DOC16/631881
SSD 7664

Notice of Exhibition - Horsley Drive Business Park Stage 2, Cowpasture Road, Wetherill Park (SSD 7664)

ATTACHMENT 1 – Office of Environment and Heritage comments on Exhibition of Horsley Drive Business Park Stage 2 (SSD 7664)

Figure 2 Horsley Park Stage 2 indicative masterplan

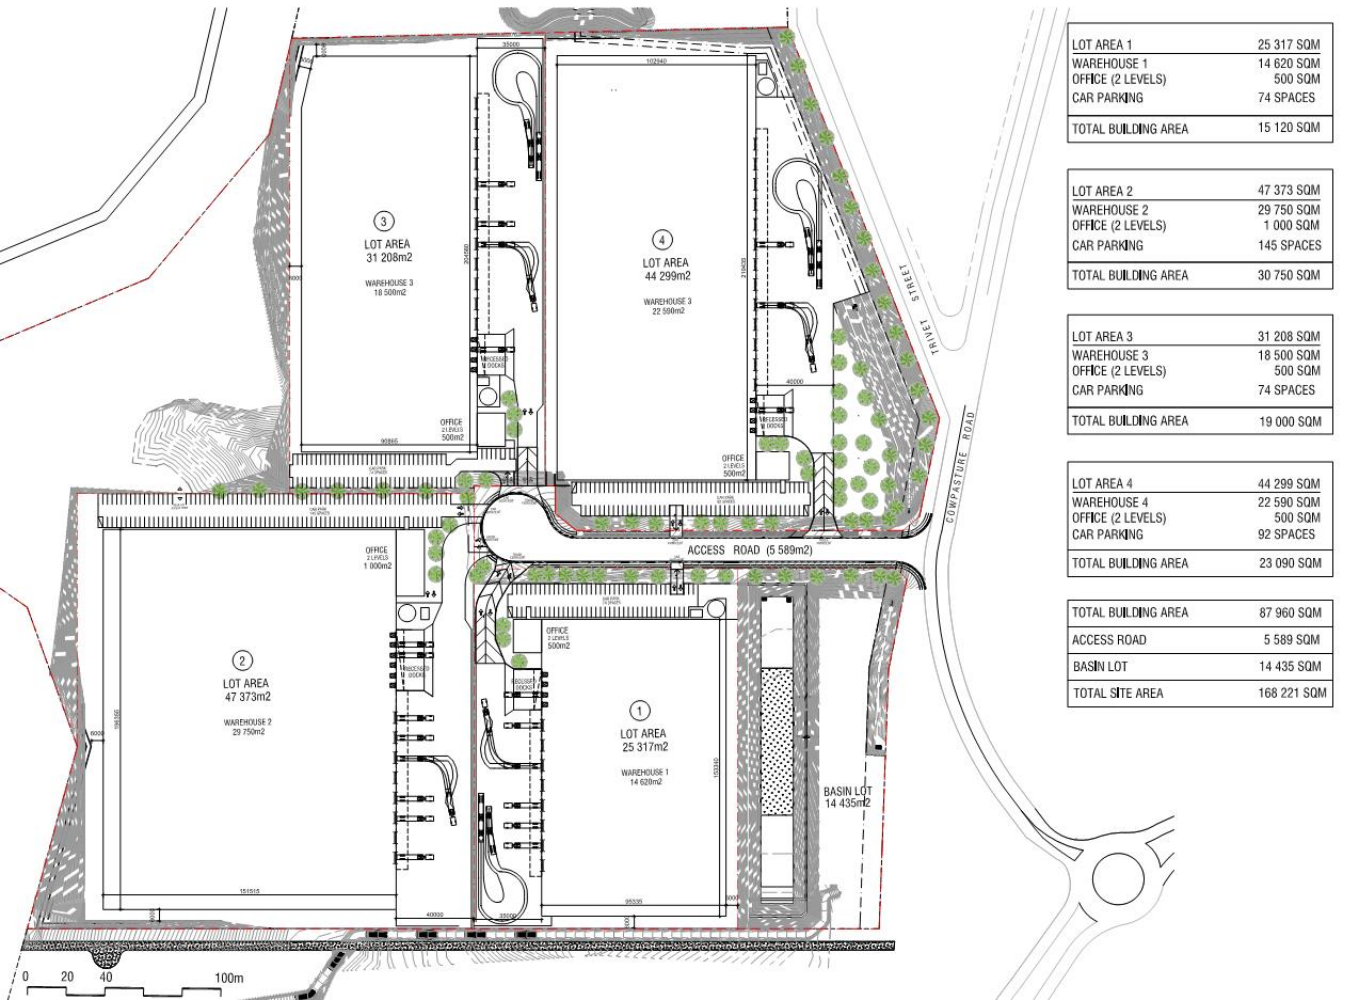
Several of the plans provided, such as the indicative masterplan and the development footprint shapefile, show something being constructed within Lot 7 of the proposed subdivision. It looks like contours on a steep slope, so may be an embankment or batter. This part of the site is mapped in the assessment as native vegetation and by OEH (2013) as CPW (PCT - Grey Box – Forest Red Gum grassy woodland on shale of the Cumberland Plain). The FBA assessment, however, does not include this in the relevant vegetation zone nor calculate the credits that would be required as an offset. It does, however, include the steeper batters north and south of this. It needs to be confirmed whether this embankment is a consequence of the development and, if it is, then the assessment must be modified to calculate the credits required to offset it.
